Application by Oaklands Farm Solar Limited for an Order Granting Development Consent for Oaklands Farm Solar Park
The Examining Authority's third written questions and requests for information
Issued on Tuesday 12 November 2024

The following table sets out the Examining Authority's (ExA's) third set of written questions and requests for information (ExQ3).

Figure 1a: Habitat constraints plan

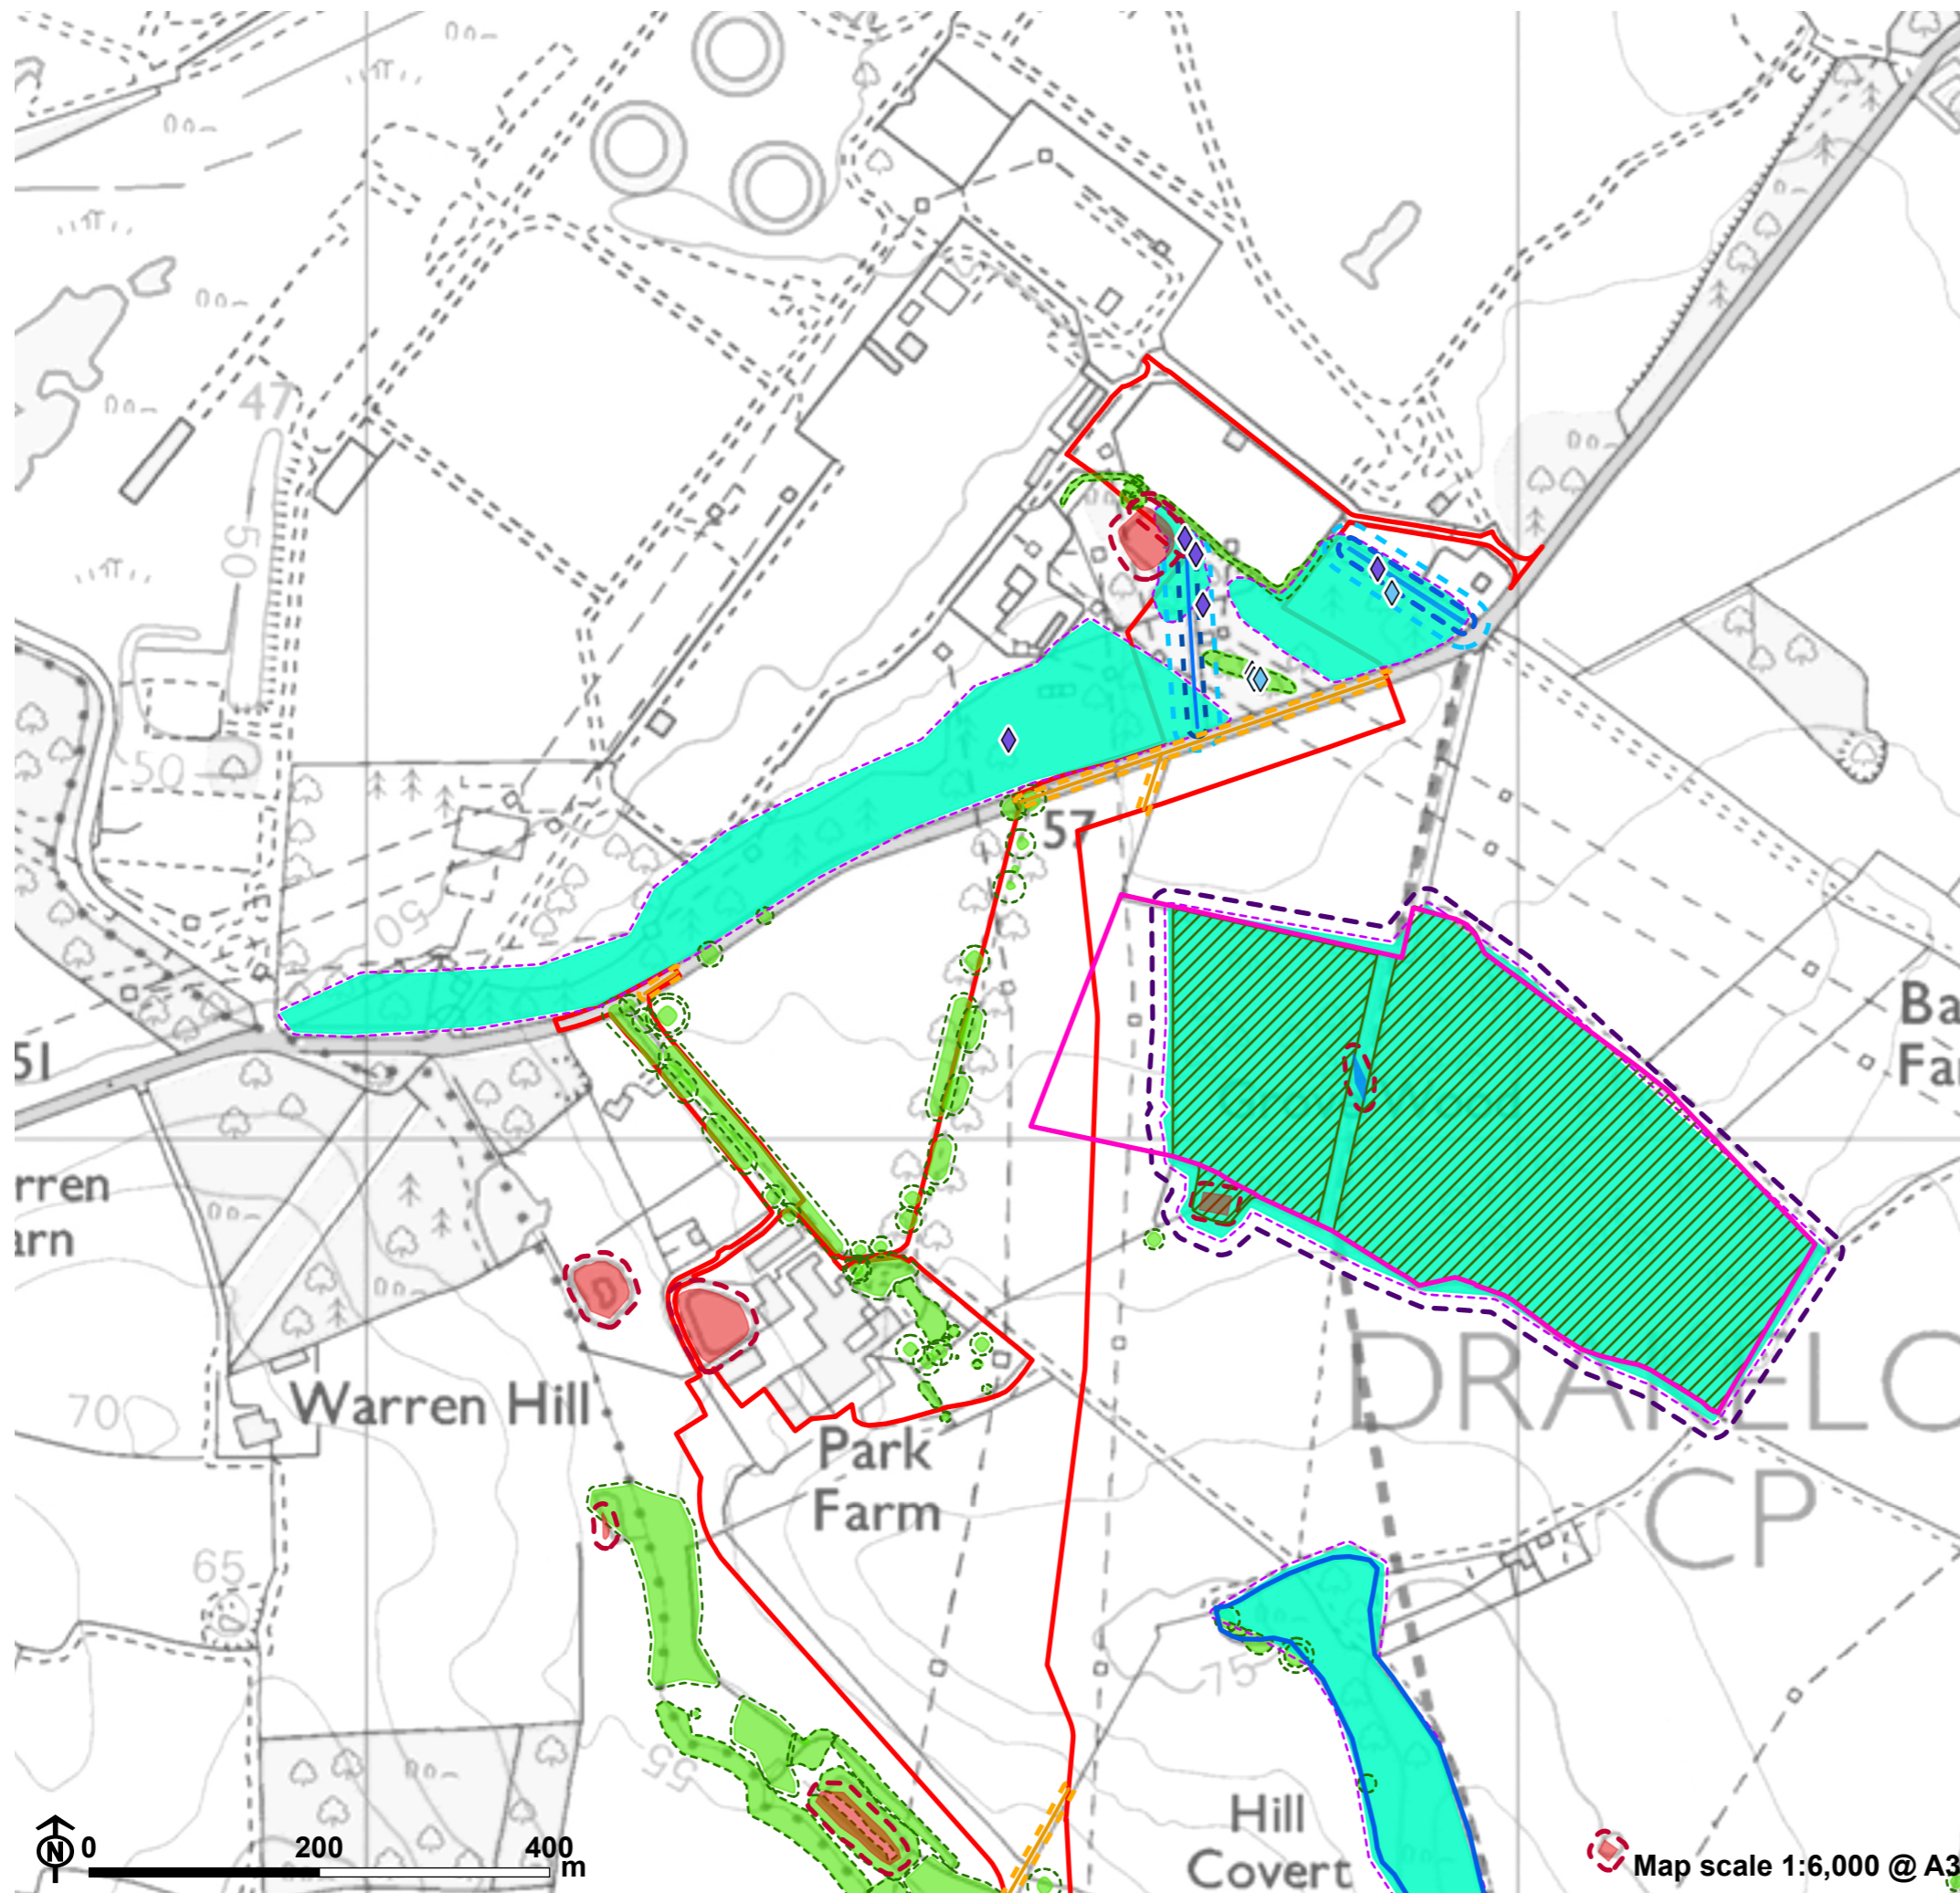
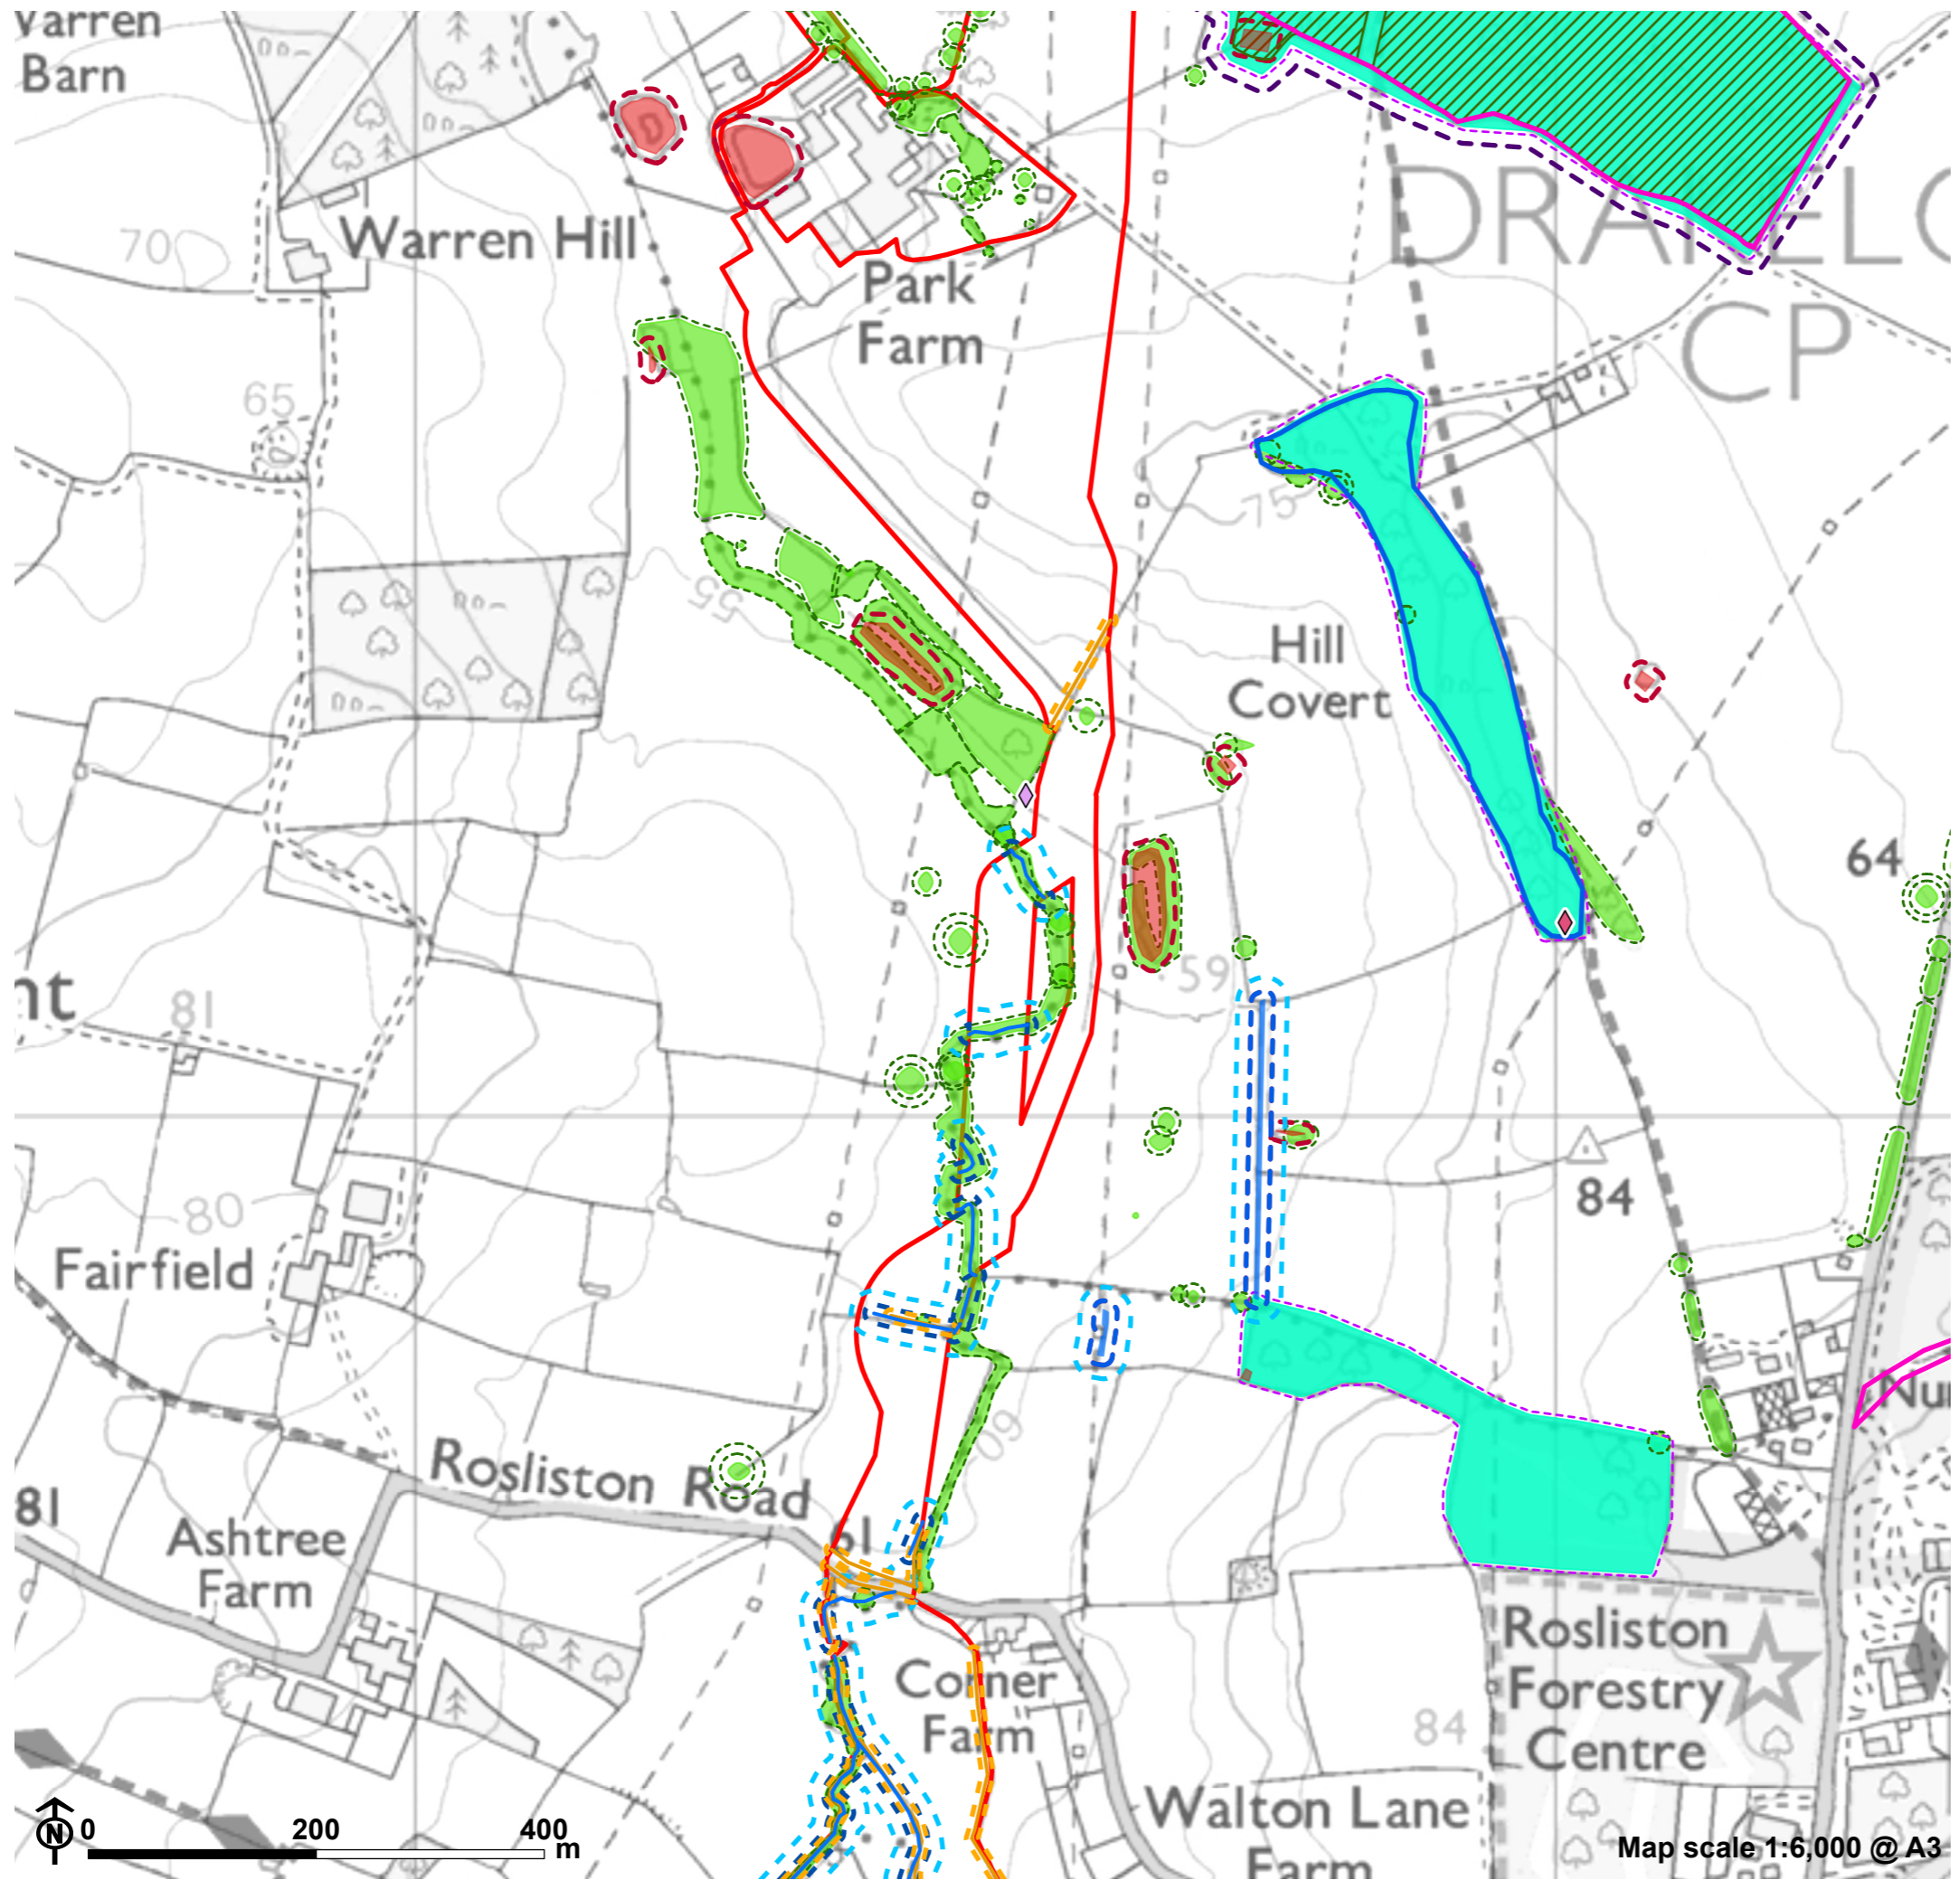
| Ref: | Question to: | Question: |
|------|--------------------------|---|
| 7.3 | Applicant SDDC DCC | <p><u>Habitat Constraints Plan</u></p> <p>SDDC [REP4-014] and DCC [REP4-012] referred to the need for a Habitat Constraints Plan with interpretable maps to provide the necessary details and extent of site clearance works relating to buffer zones to sensitive features such as ancient/ veteran trees, other retained trees, ponds, watercourses, hedgerows and woodlands.</p> <p>The Outline CEMP [REP5-011] includes provisions for a Habitats Constraint Plan [Section 2.8.5] and buffers [Sections 2.6.4, 2.6.5, 2.8.2, 2.8.3, 2.8.5, and 2.8.6]. The Applicant provides a series of interpretable maps of habitat constraints [REP5-030].</p> <ul style="list-style-type: none"> a) Please could the Applicant add the draft interpretable maps to the Outline CEMP [REP5-011] and secure that interpretable maps be included in the final CEMP? b) Please could SDDC and DCC comment? c) Please could SDDC and DCC also summarise any outstanding concerns at Deadlines 7 and 8 with suggestions about how they might be addressed? |
